<b>Consultation Response from KC, Highways Development Management</b>
<b>2025/91576 Land adj, 47, Cresswell Lane, Heckmondwike, WF13 4PJ</b>
<b>Erection of detached dwelling</b>
<b>Date Responded: 27/01/2026. Responding Officer: D. Stainsby Responding Ref: K14-7SE/2</b>

SITE PLAN 1:500

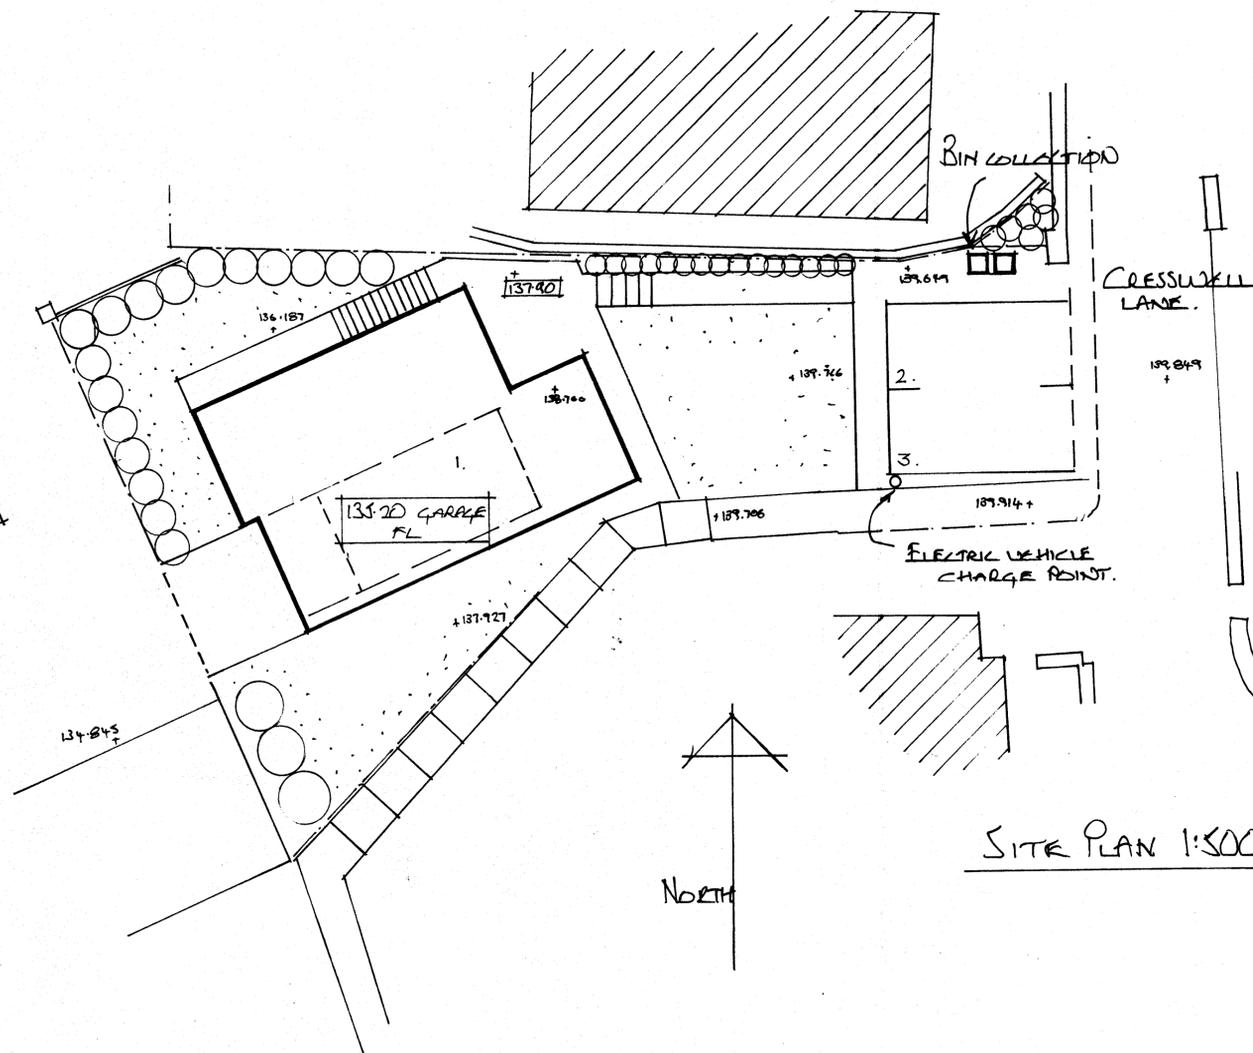
For a 30mph speed limit, sight lines of 2.4m x 43m should be achievable and demonstrated on a suitable plan, any shortfall of this requirement should be in accordance with 85%ile wet weather speed readings (if below 30 mph).

A revised layout showing the required visibility splays can be met should be provided to ensure that the minimum visibility can be provided for vehicles leaving the site onto Cresswell Lane.

The red line boundary for the application needs to be extended to the adopted highway to demonstrate that vehicular access can be achieved.

A revised plan showing the amended red line boundary should be submitted.

Parking for 3 cars have been provided, one in an internal garage accessed from Lyndale Mews and two off street parking spaces accessed from Creswell Lane.

The internal layout is acceptable.

A bin collection/presentation is shown adjacent to the adopted highway on Creswell Lane and is acceptable.

An adopted public footpath between Lyndale Mews and Creswell Lane runs along the southern perimeter of the site.

This route needs to be maintained during and after construction and any works agreed to provide for and ensure the safety of the user.
